Consultation response from KC PROW (footpaths)

2023/90816 2 Hollin Hall Lane, Scapegoat Hill

Demolition of existing building and erection of dwelling with associated external works and erection of detached garage

Date Responded : 3/5/23

PROJECT TITLE <b>HOLLIN HALL LANE</b>			
DRAWING TITLE <b>BLOCK PLAN</b>			
SCALE <b>1:500</b>	DRAWN <b>EG</b>	CHECKED <b>JH</b>	PROJECT REFERENCE <b>ODS 22/519</b>
PAPER SIZE <b>A3</b>	DWG NUMBER <b>(20)003</b>	DATE <b>01/03/23</b>	REVISION <b>A</b>
CLIENT <b>MR &amp; MRS WOLSTENCROFT</b>

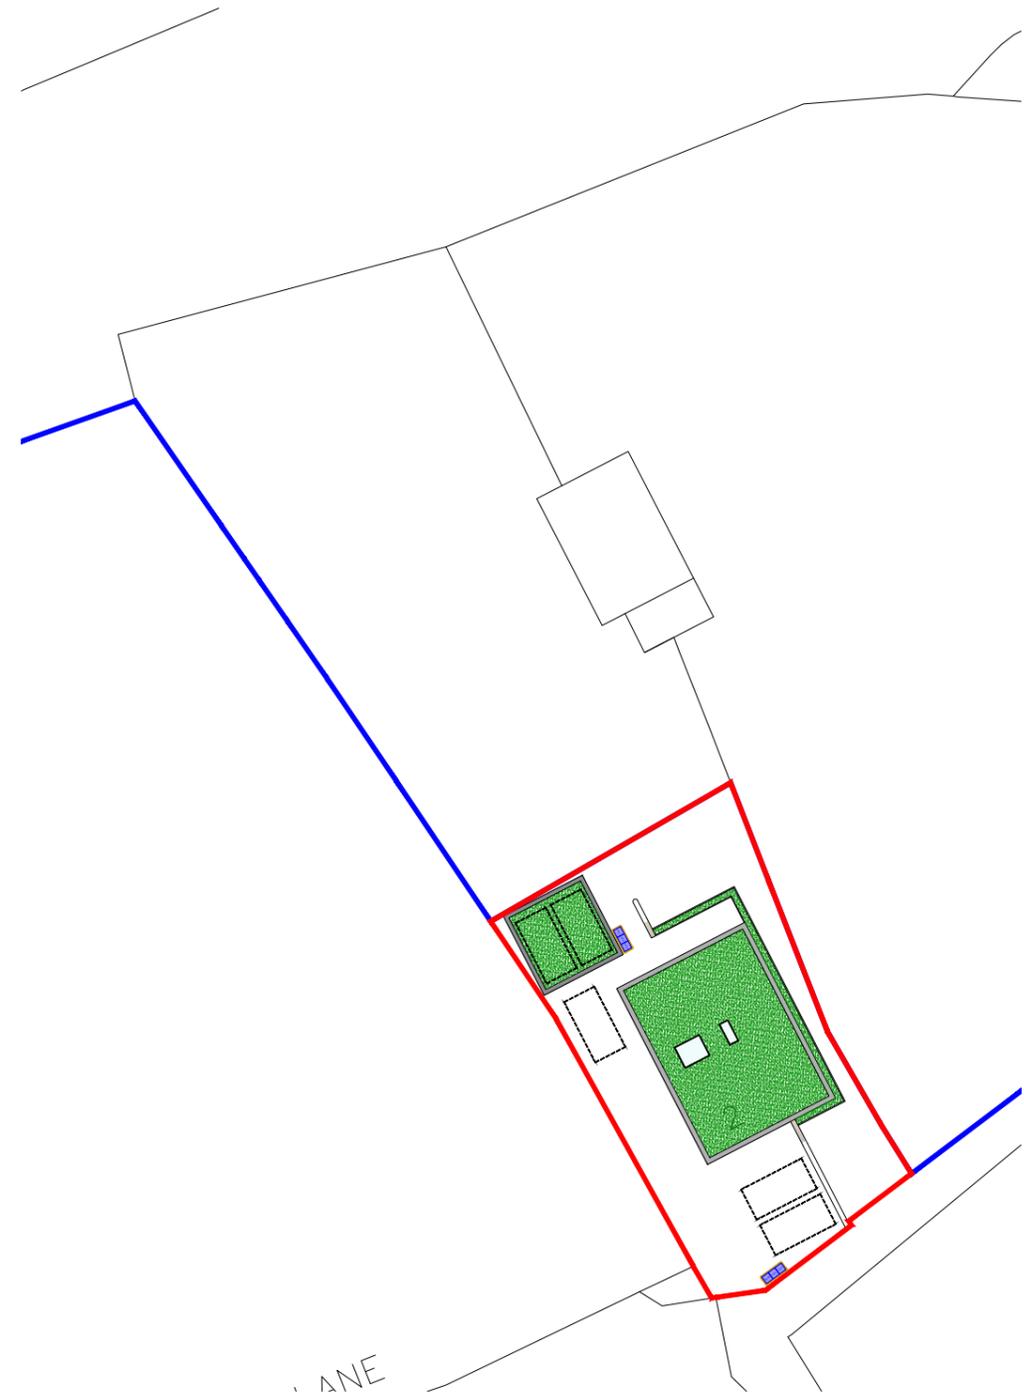
The first part of the access to the development is a public bridleway however this has not acknowledged or shown on any submissions with the application. No authority is given for any change to the surface of the bridleway without the authority of public rights of way team.

FOOTNOTE Public bridleway Colne Valley 240 is adjacent to the development site and must not be interfered with or obstructed, prior to, during or after development works.
